From: Phil Beechinor [REDACTED]
Sent: 09 April 2019 20:26
To: Anita Gardner
Subject: Fwd: A/31/19/PL development of the land between Ashurst & Badgers , Ham Manor Way

From: Phil Beechinor [REDACTED]
Date: 9 April 2019 at 20:18:30 BST
To: anitagardner@arun.gov.uk
Subject: A/31/19/PL development of the land between Ashurst & Badgers , Ham Manor Way

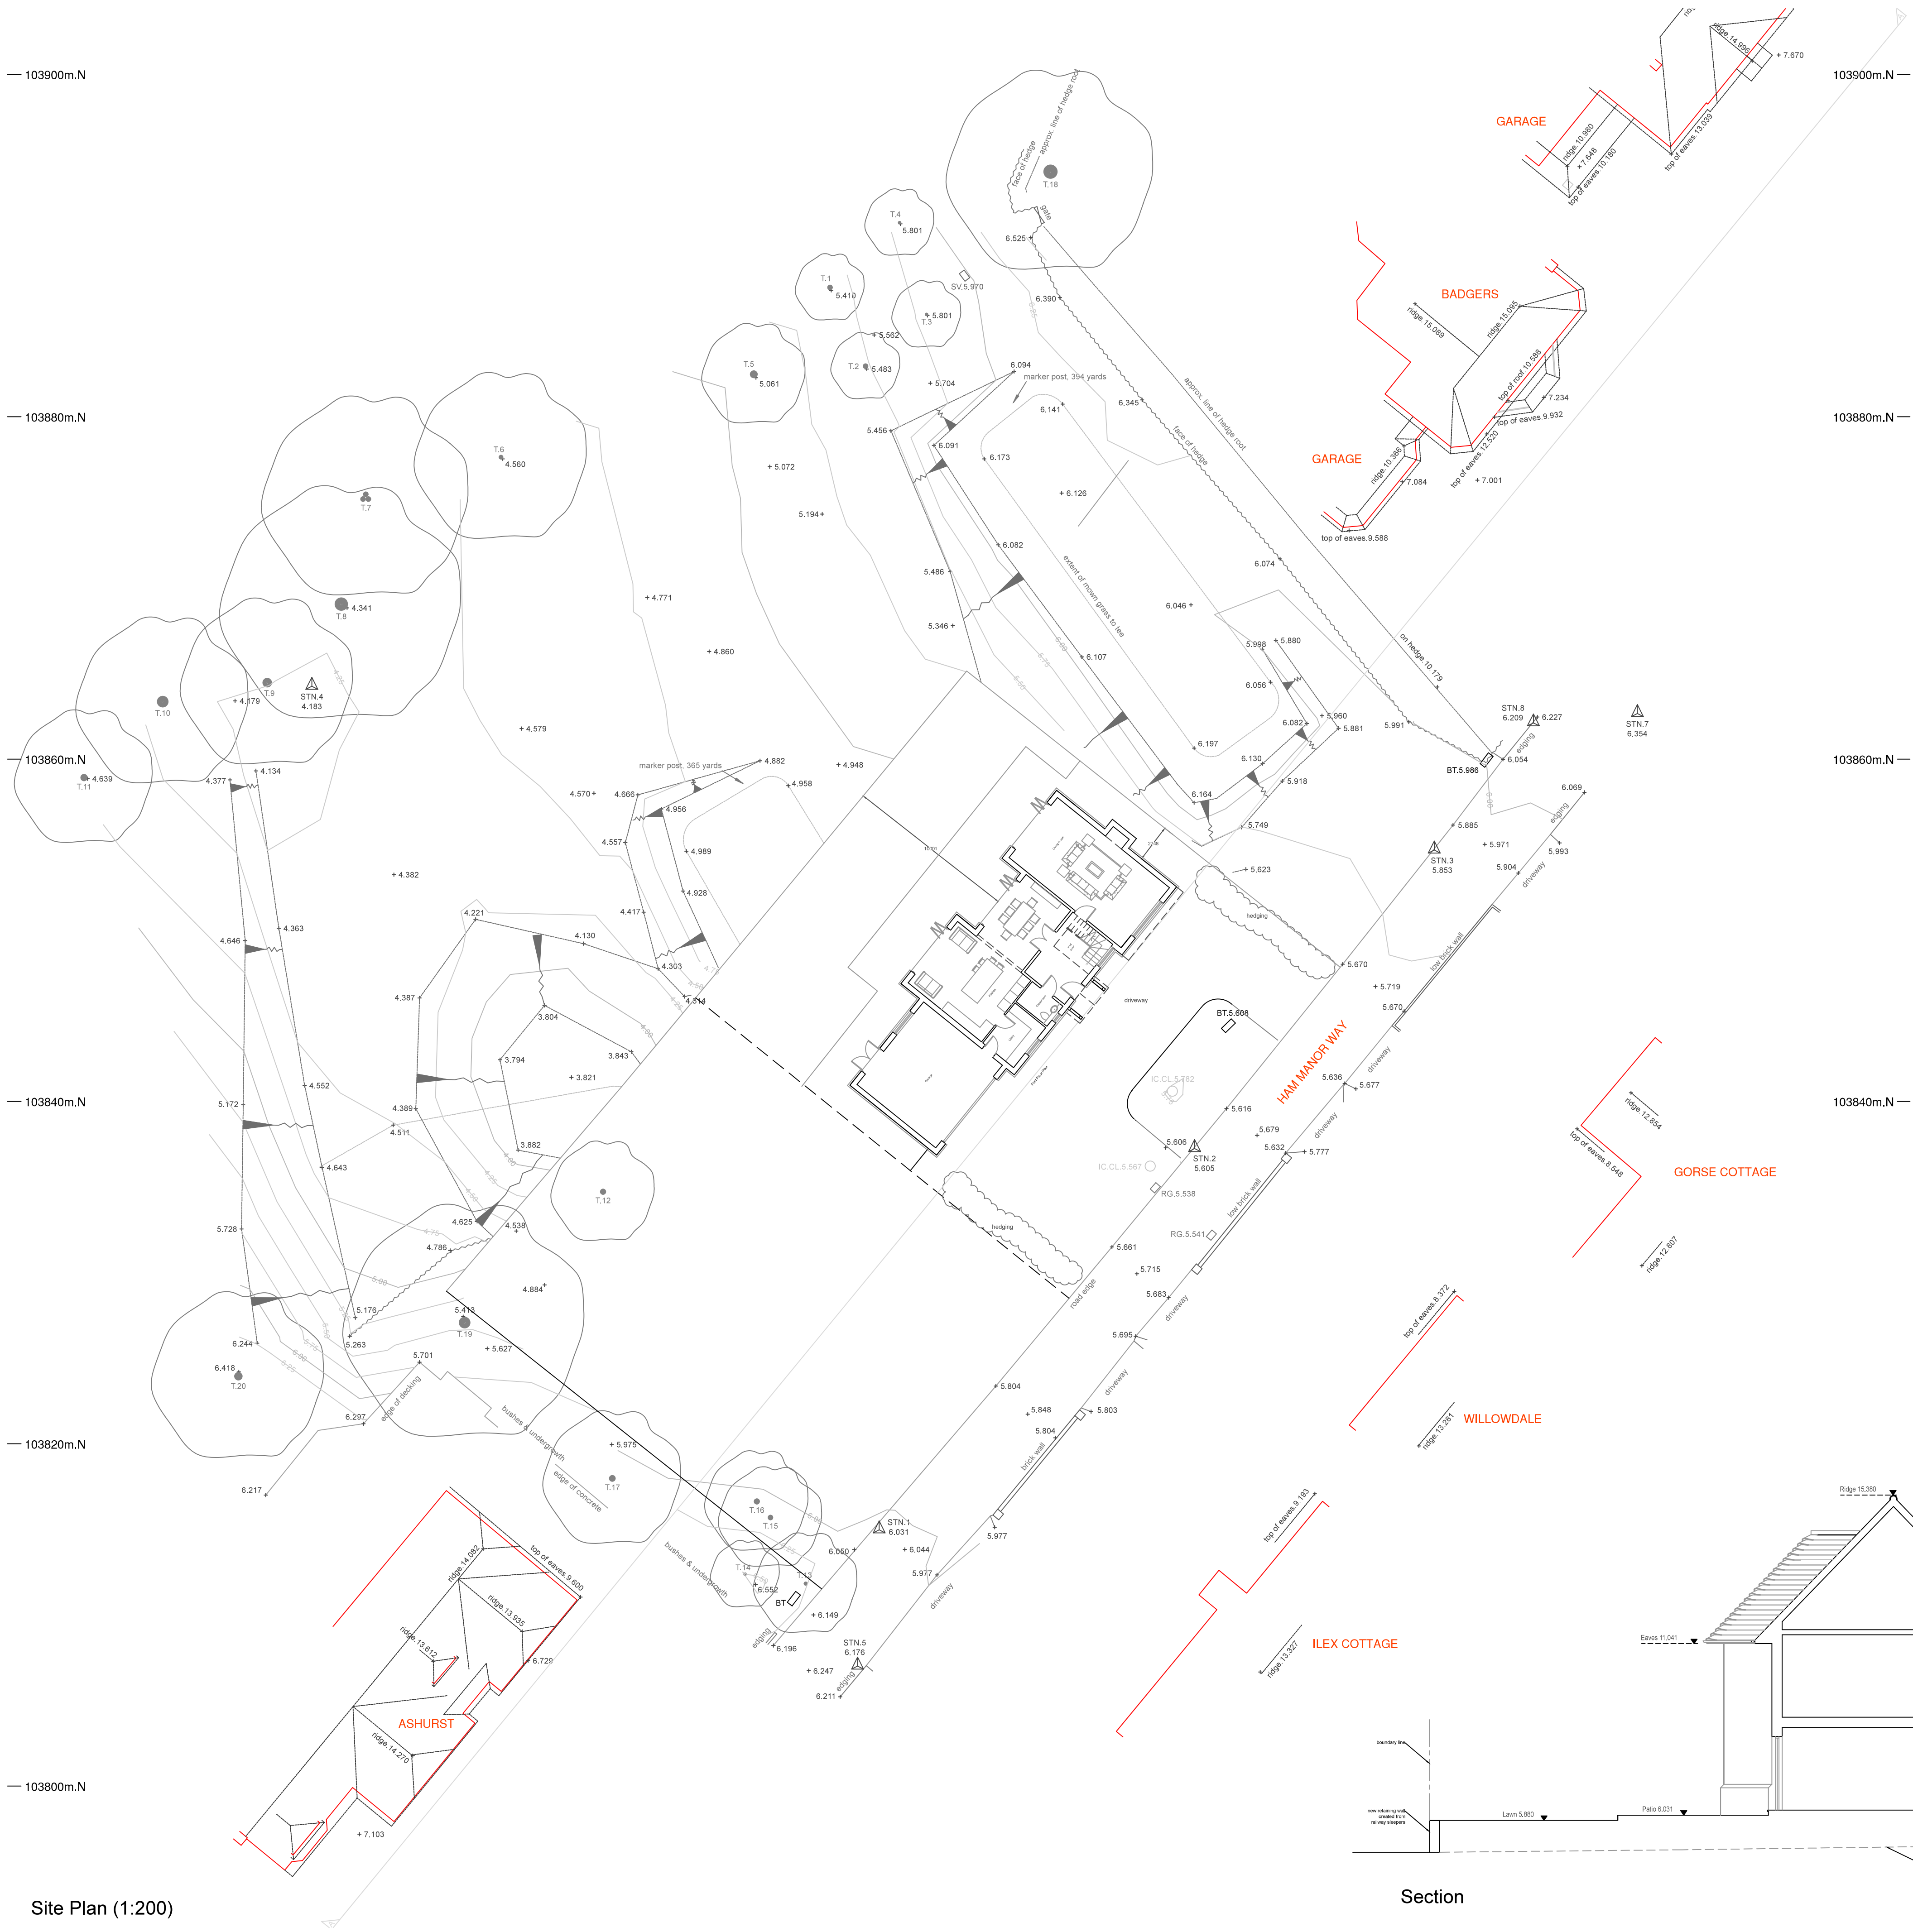
The building line is forward of existing properties , Badgers to the North and Ashhurst to the south. I understand that this has been necessary to allow for an adequate back garden under modern regulations, but surely it will not be allowed as it only moves this very large building even closer to the smaller chalets and bungalows opposite.

The depth of the CLP plot is shallow and a much smaller property is required to fit the space.

Side Elevation (south)

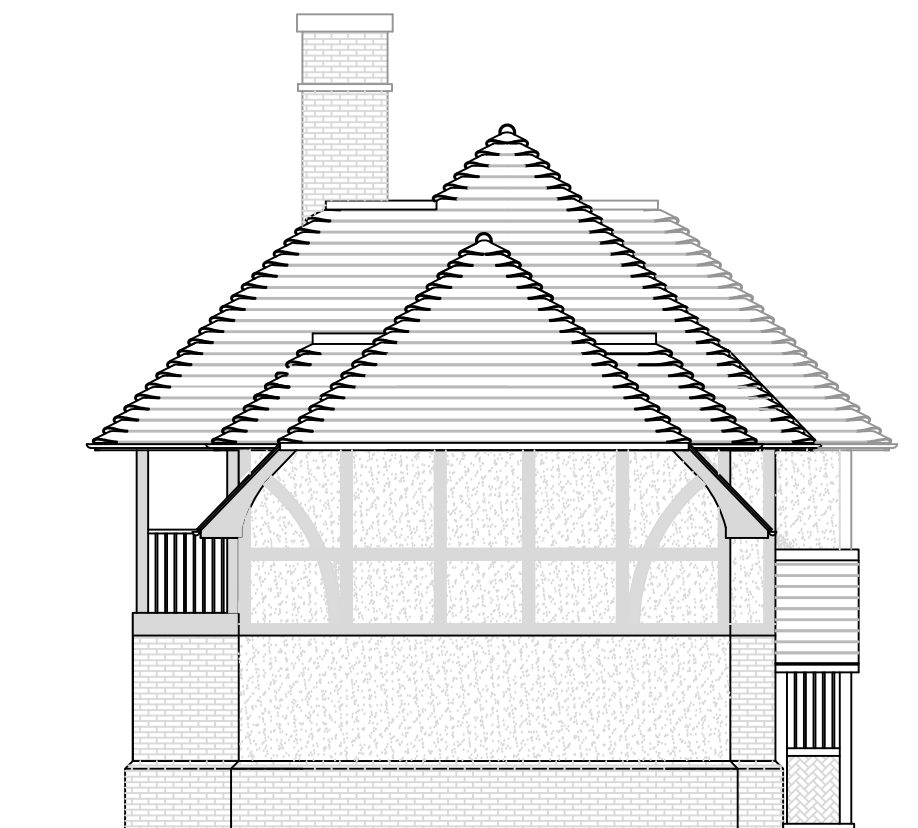
There are no windows on the south wall and one can only assume that a further application will be made for another property to the south. This will be even worse for the local residents , as it will represent overpowering buildings , where before there was a beautiful open protected Green Space.

Street Elevation (1:200)

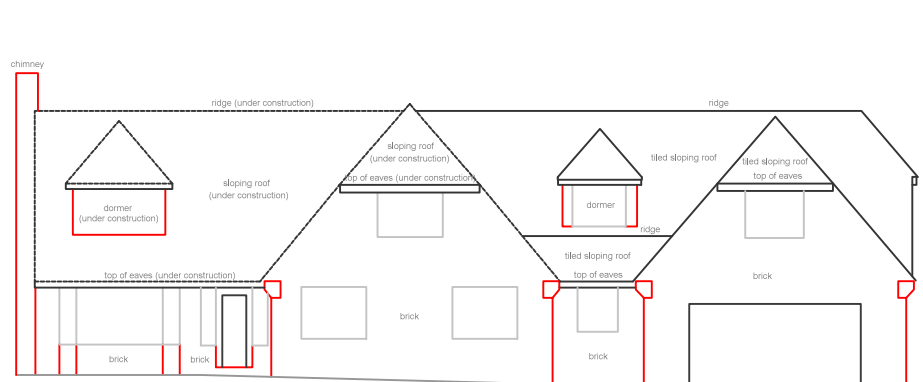
This new property is very large and does not in any way match the street scene. There are bungalows and chalet bungalows immediately opposite and up Ham Manor Way to the south.
